From: Julie Grieves
Sent: 28 September 2015 11:20
To: 'derek.treagus@gmail.com'
Subject: RE: Langham Legh -Ref EG/43/15/HH

The block plans you have sent do not have the measurements to the boundary written on them. Please forward amended plans to show the measurements from the proposal to the boundaries.

BRICK PLAN scale 1:500 @ A4

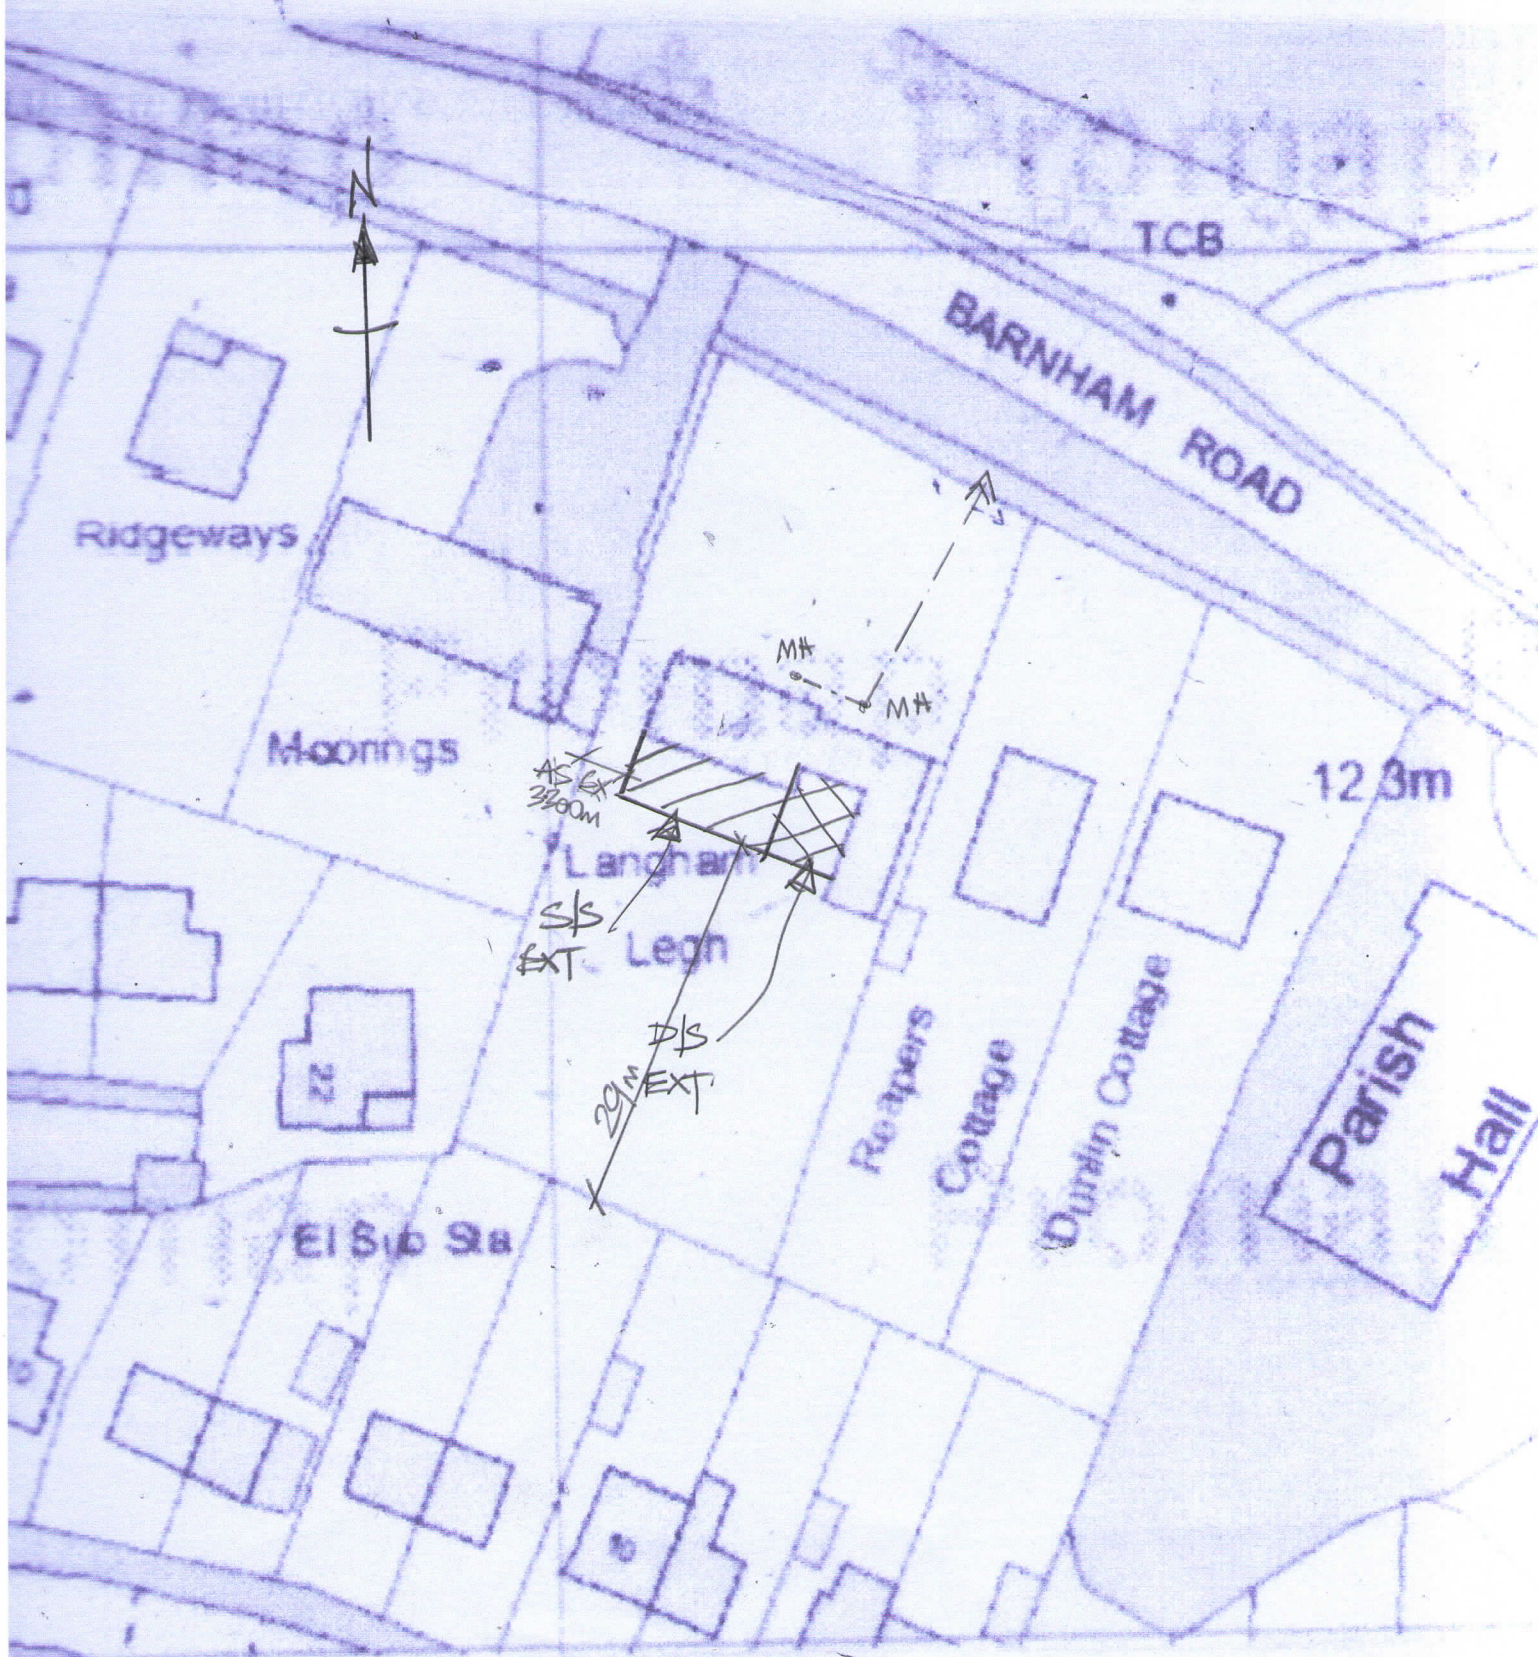
Yes, for all extensions, measurements are required to the boundary, as per the notes.
